# **SSD 6633 - SICEEP Darling Square - Mixed Use Residential Building within the South-East Plot**

**Submission by:**

**Cavan & Mira Hogue**

## SSD 6633 Submission

FACADE SYSTEMS

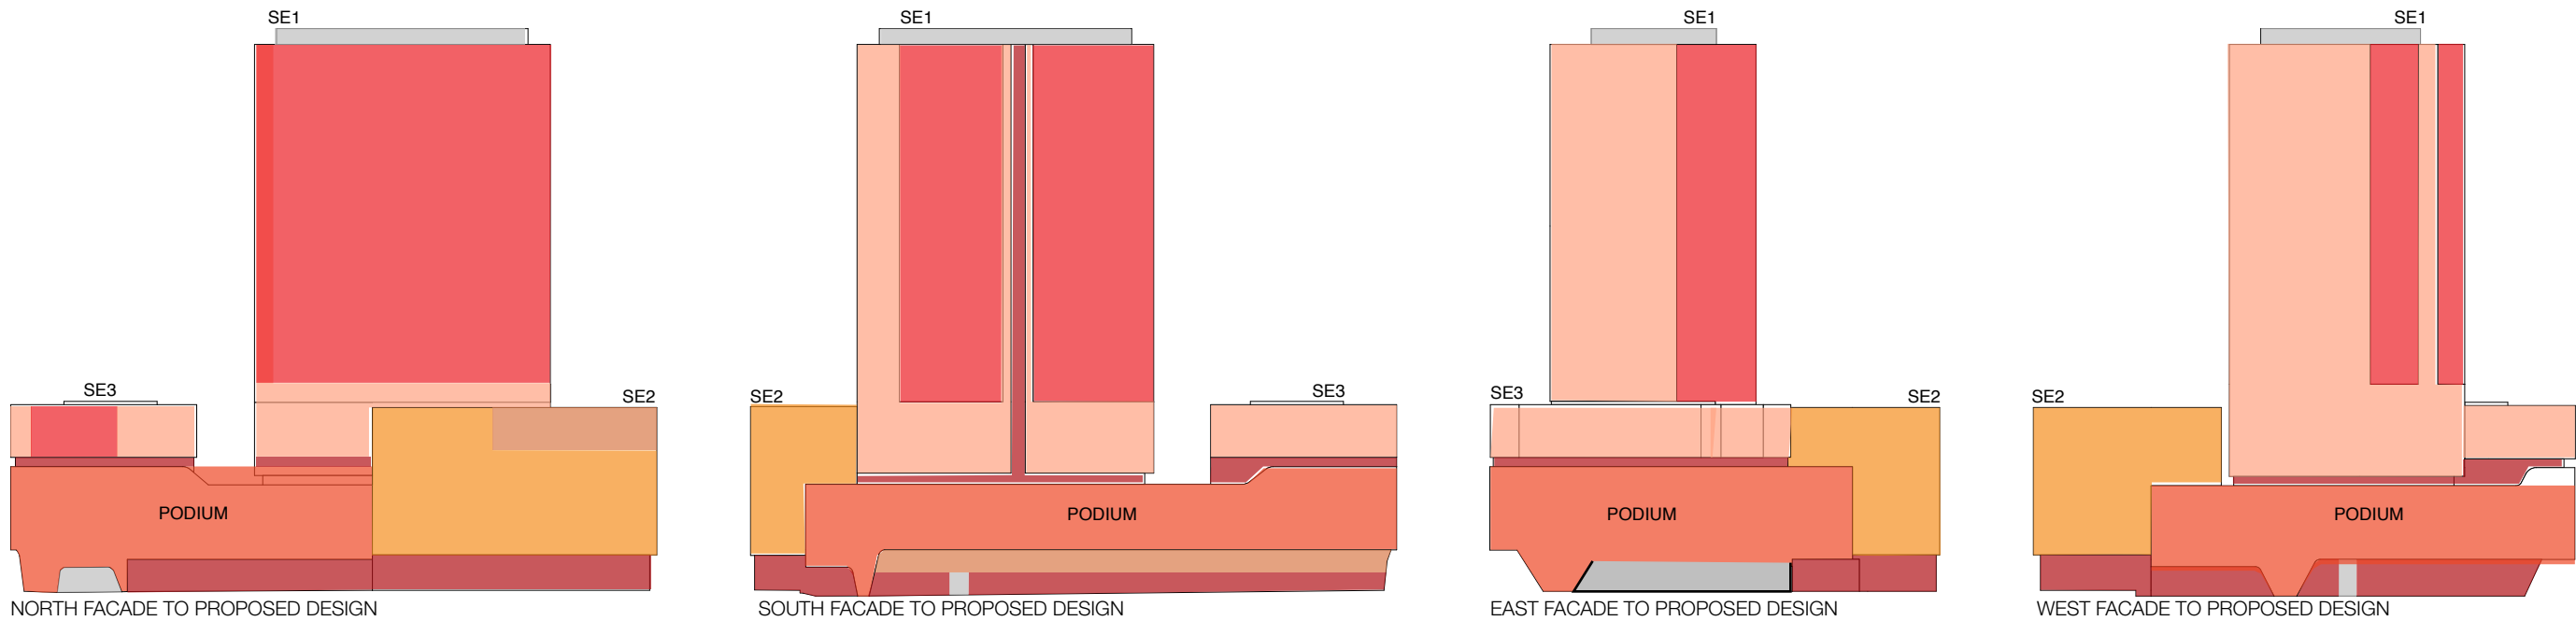
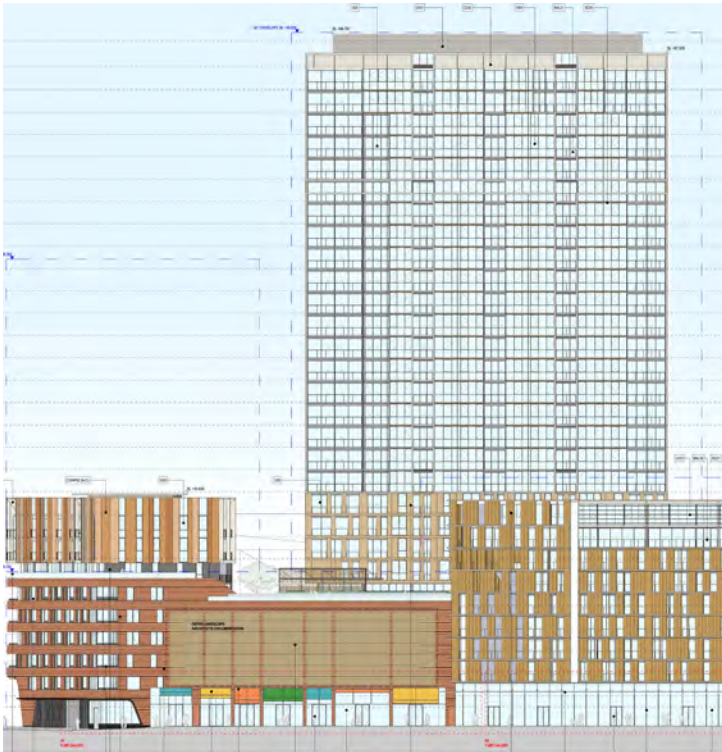
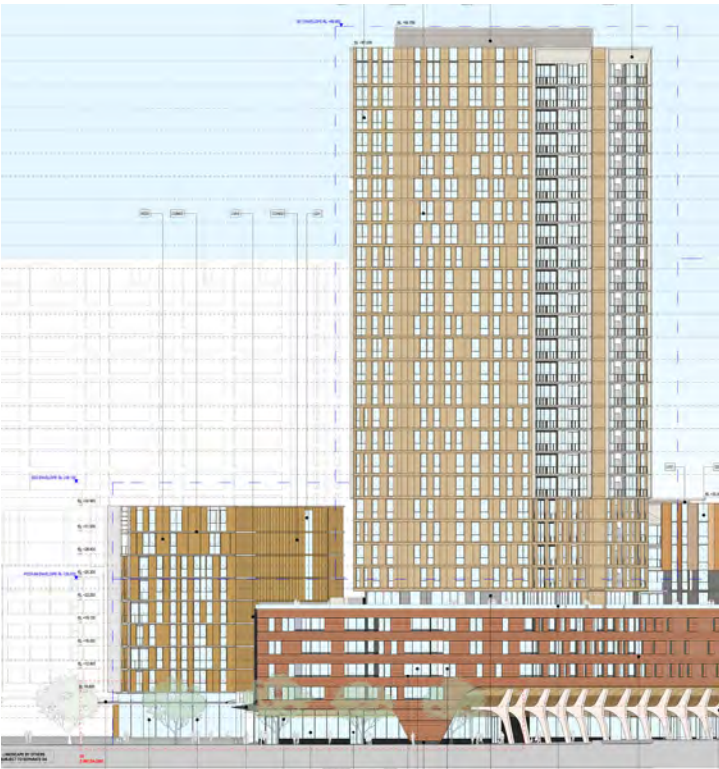
<p>EIS 3.4.2 page 37. Figure 21, building SE1 southern elevation</p> <p>There is no brise soleil.</p> <p>Appendix B Design Report 07A, p64</p> <p>Façade system diagram, building SE1 southern elevation</p> <p>There is a brise soleil.</p>	<p>The two documents are contradictory.</p> <p>The proponent has rushed this document and is still undecided about the materials and finishes.</p>
<p>On all facades of SE1, there is no use of any bright colours.</p>	<p>The proponent is overwhelmed by the task of designing a large residential building which is also attractive. The SE1 building appears to be commercial or institutional rather than residential.</p>
<p>EIS 3.4.2 page 42</p> <p>"The façade of Building SE3 is composed of a geometric collage blending autumnal tones to create a finely scaled screen of warm hues. "</p>	<p>The proponent is unwilling or unable to apply the genuine colour creativity which it displays in the small building SE3 in the much larger building SE1.</p>

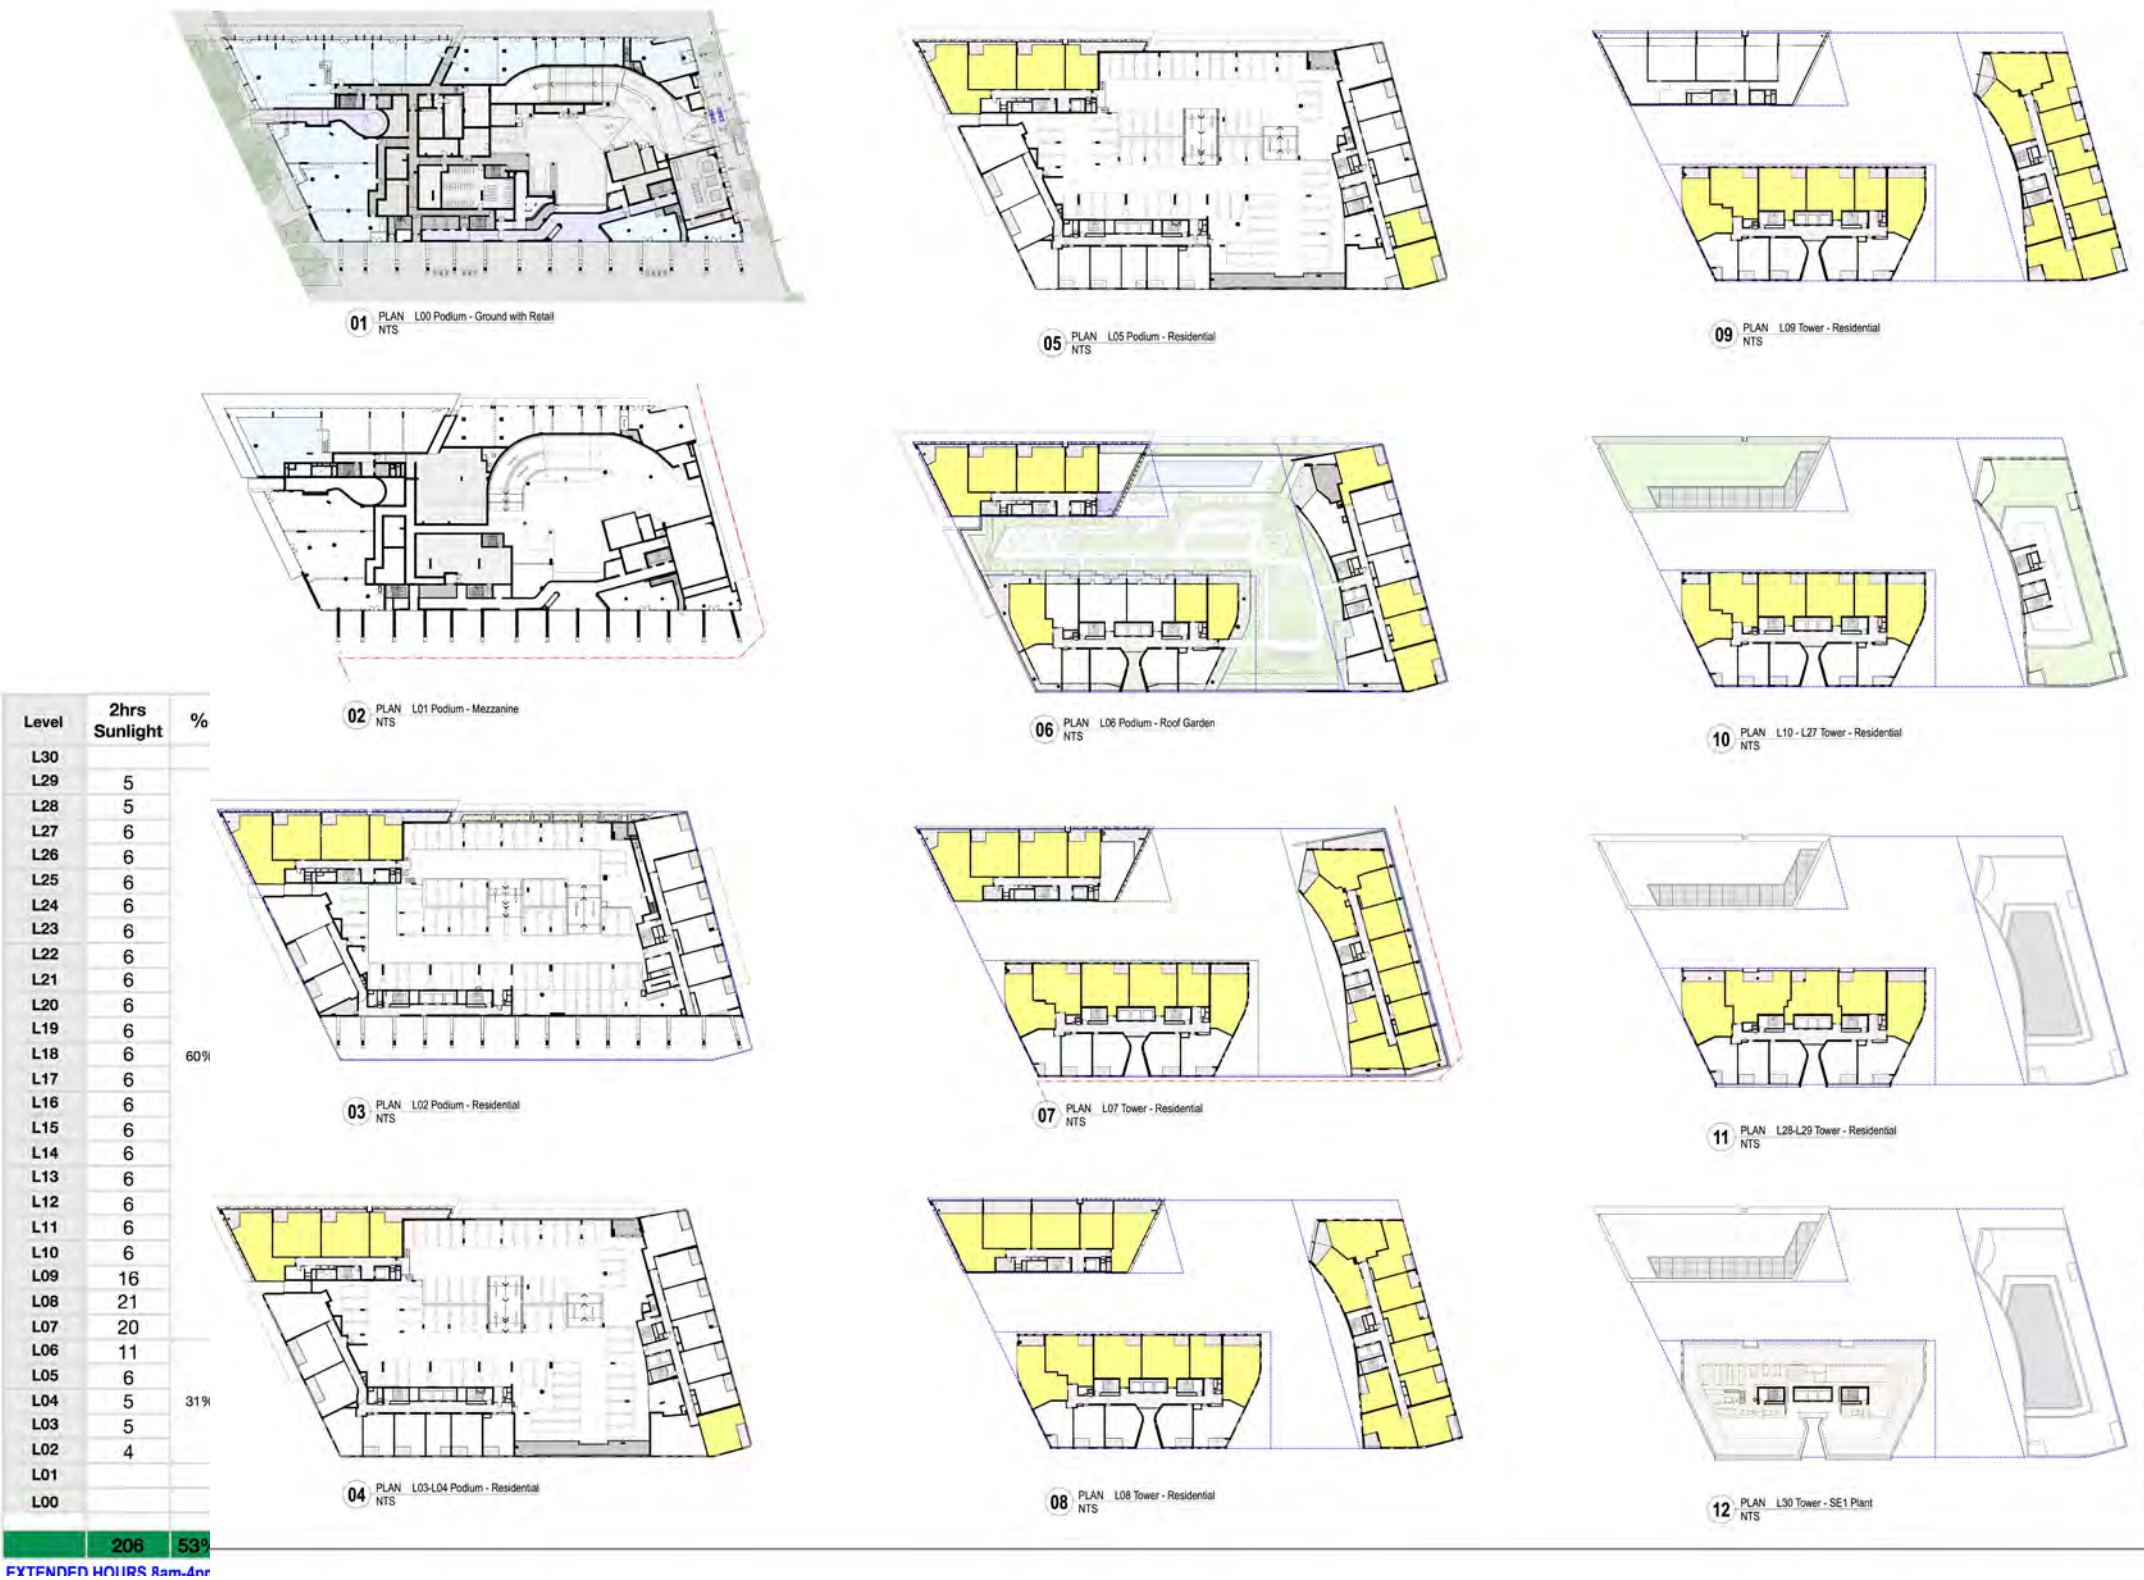
The Proposal	Comments by this Submission
<p>Appendix B Design Report 07A page 75</p> <p>"Overshadowing on the site comes from the adjacent Haymarket development (affecting the western facade and podium), and the recently approved Greenland tower. The Stage 1 Concept Proposal (SSDA 2) assumes an average of 70% of apartments for the entire precinct and 71% of apartments in the South East Plot would comply with the 2 hours of solar access to living spaces under the RFDC.</p> <p>Between the core hours of 9am and 3pm 47% (183 / 391) of apartments receive sunlight.</p> <p>Between the extended hours of 8 am and 4 pm the number of apartments receiving 2 hours or more solar access is 53% (206/391). The extension in time sees an increase of 23 apartments receiving 2 hours or more of sunlight. Detailed elevational shadow analysis is provided on the following pages showing the sunlight throughout the extended hours noted above.</p> <p>When the scheme is viewed in its Tower (L07 to L29) and Podium (L01 to L06) components the solar performance of the building is more clearly illustrated.</p> <p>The Tower component contains 290 apartments of which 174 (60%) achieve compliance.</p> <p>The Podium component contains a further 101 apartments of which 31 (31%) achieve compliance.</p> <p>Its important to note that the podium contains only 26% of the total apartments yet accounts disproportionately for 38% of the non-conforming apartments.</p> <p>The podium apartments have been designed to optimise their access to natural light whilst achieving high levels of both visual and acoustic privacy. The resulting solar performance outcome is a good result given the overshadowing of adjacent developments, and orientation of the podium."</p>	<p>There is no provision in either the Apartment Design Guide or the Residential Flat Design Code to consider hours other than from 9 am to 3 pm.</p> <p>It is pointless saying that the Tower is more compliant than the podium; what matters is the overall compliance. Of course, the podium, which achieves only 31% compliance, would be better suited to non-residential uses.</p> <p>It is pointless saying that an apartment has some natural light; any apartment which is not underground or completely internal will have some natural light. But natural light does not constitute solar access in terms of the Apartment Design Guide or the Residential Flat Design Code, which both refer to direct sunlight and not mere daylight.</p> <p>The inescapable conclusion is that the overall compliance during the relevant hours is only 47%, which is far below the figures of 70% laid down by both the Apartment Design Guide and the Residential Flat Design Code.</p> <p>It is pointless saying that a good result has been achieved in the circumstances of other approved overshadowing developments nearby. It is doubly pointless to say this when one of the developments is being carried out by the same developer as the current proposal. It is triply pointless to say this when the City of Sydney was opposed to developing four residential towers on the Haymarket site and the building envelopes for four towers were approved in the face of opposition by the City of Sydney.</p> <p>The only thing that matters is what result is achievable on that site and, as a consequence, whether that site is fit for human habitation to NSW standards on the lower levels.</p>
